# Rezoning Transportation Analysis

Petition Number: #2021-256

## Revision Log:

Date	Description
04-12-2022	First Review (AO)
08-22-2022	Second Review (AO)

Aug 15, 2022  
H:\2021\NCC212802\CAD\DRAWINGS\PLAN SET\REZONING\NCC212802 - RZ-3 - 1\JOB\OUT - RZ-3 CONCEPTUAL SITE PLAN.dwg

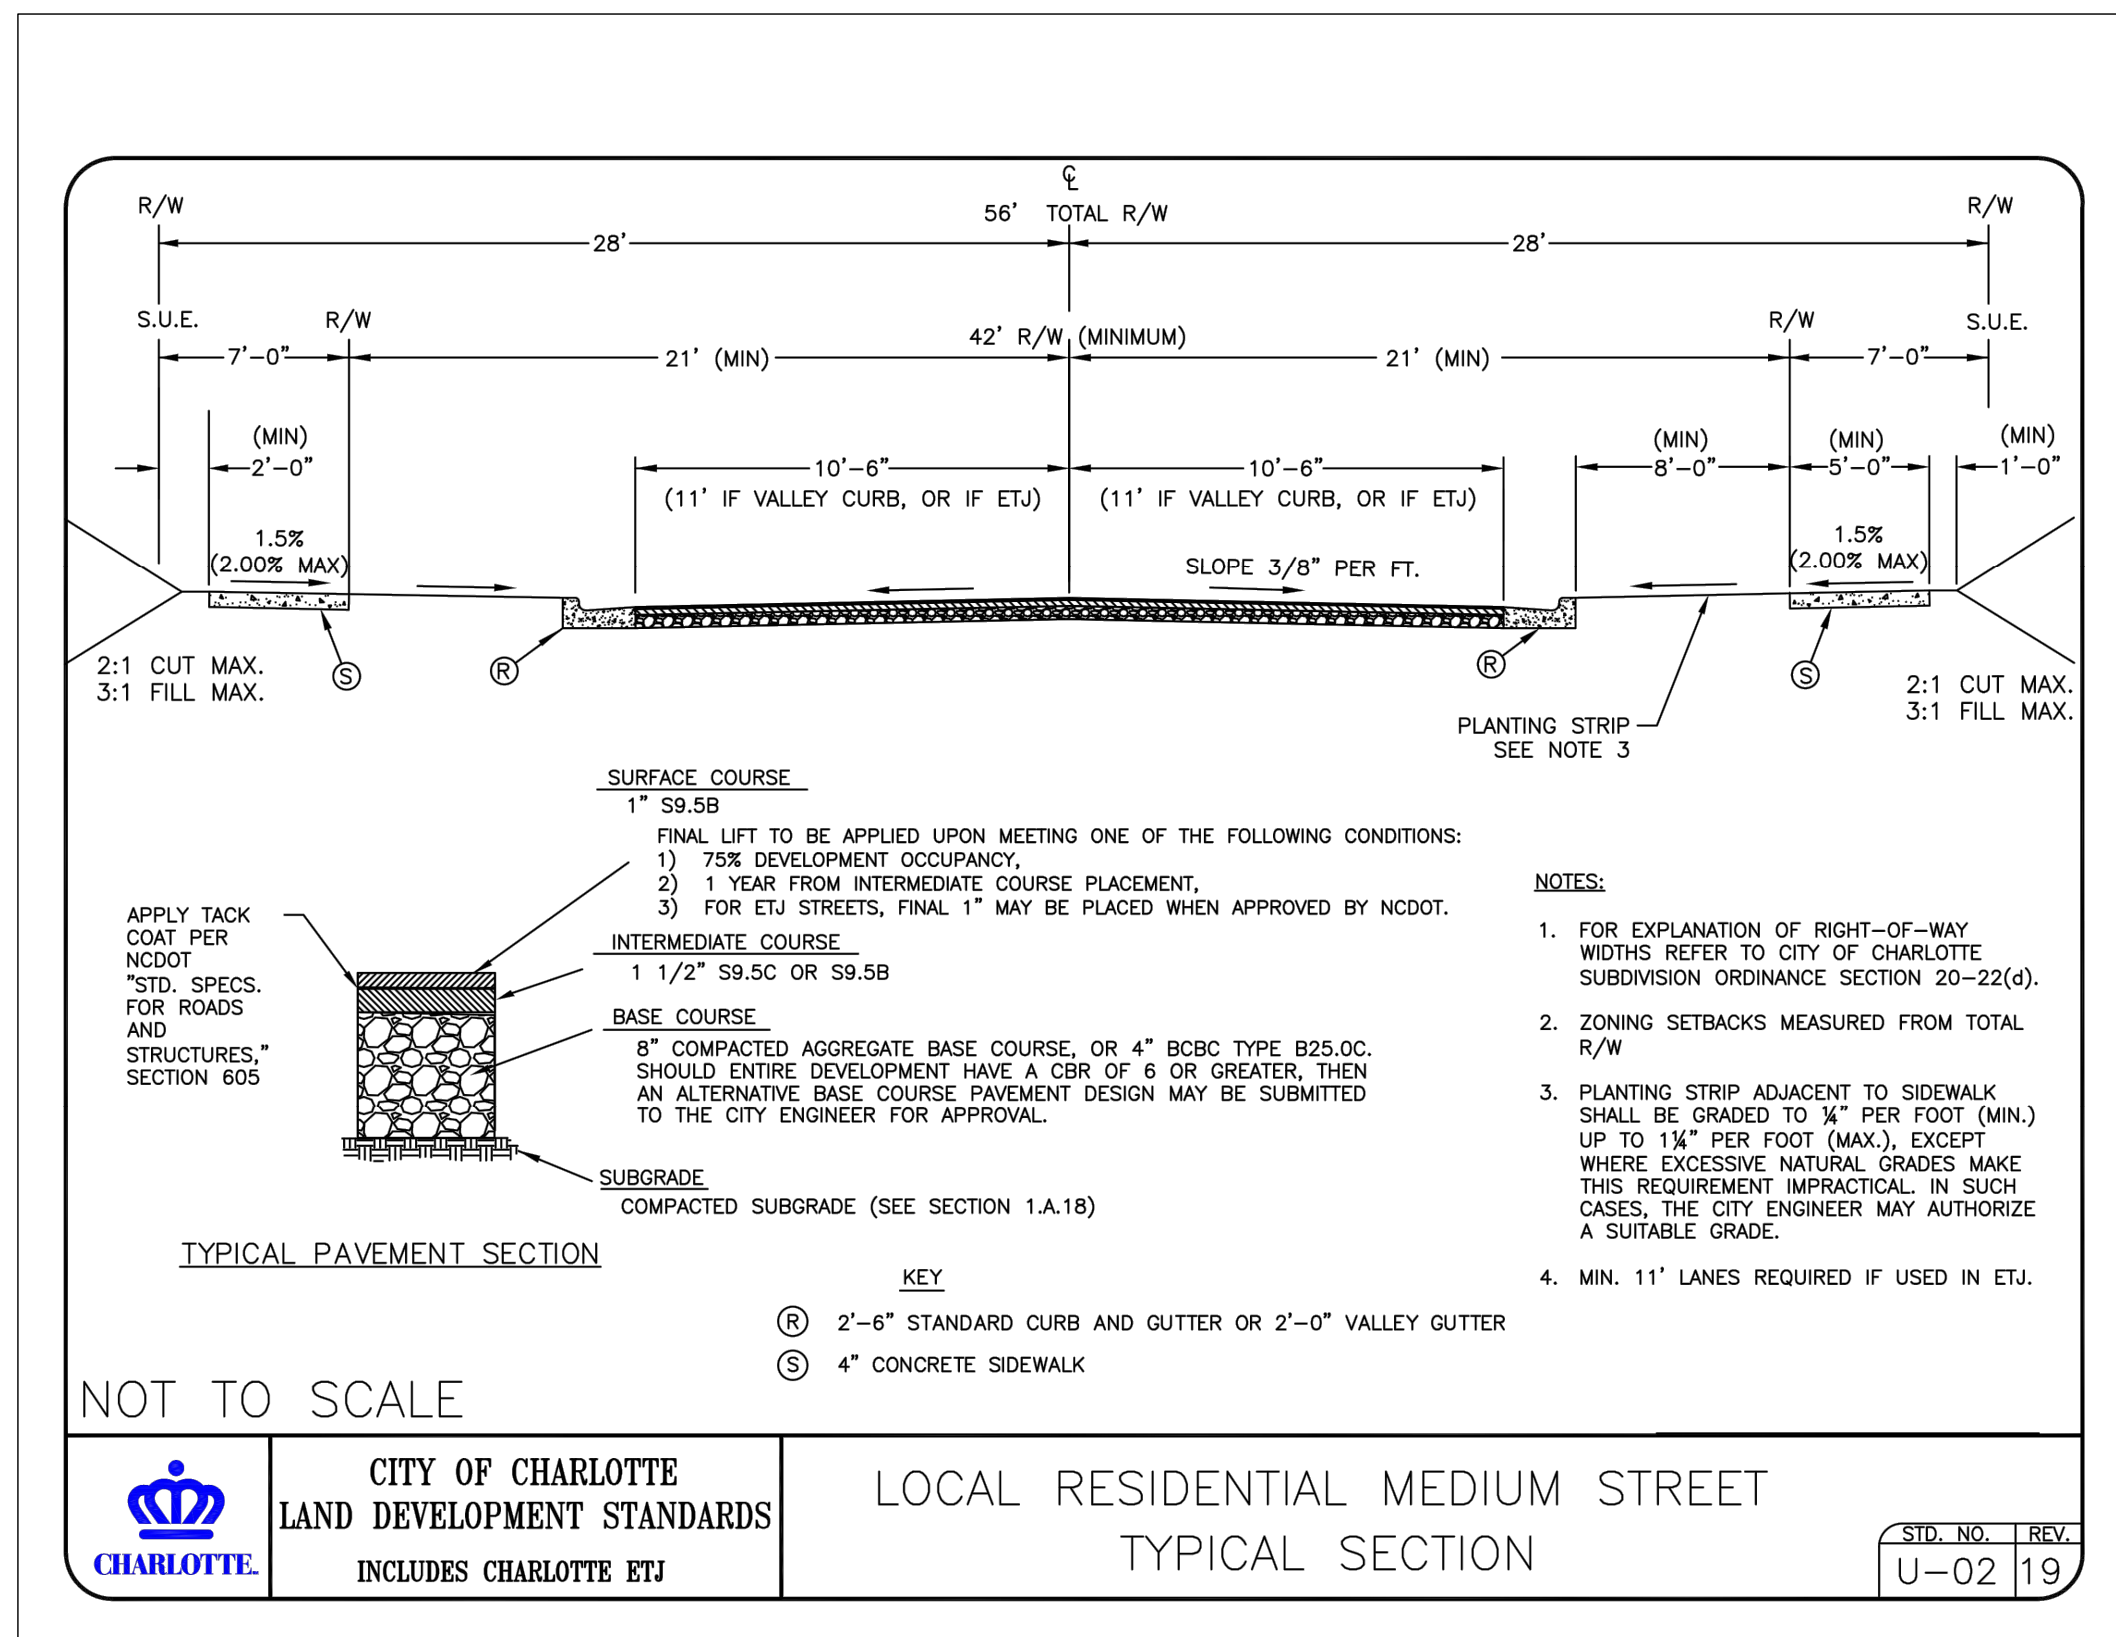
7. ~~Revise site plan to reflect most recent alignment/ design of XCLT Orr to Rocky River plans, including all easements acquired by the City through condemnation and approved by City Council on March 28, 2022.~~
8. **Outstanding Comment from 4-12-22:** Revise site plan and conditional note(s) to commit to constructing a 12' multi-use path connecting Neal Drive to Development Area "A" to provide connectivity from XCLT to eastern leg of Neal Drive.

**Update to Comment:** Add multi-use path to site plan sheet RZ-3 and add conditional note to development standards.
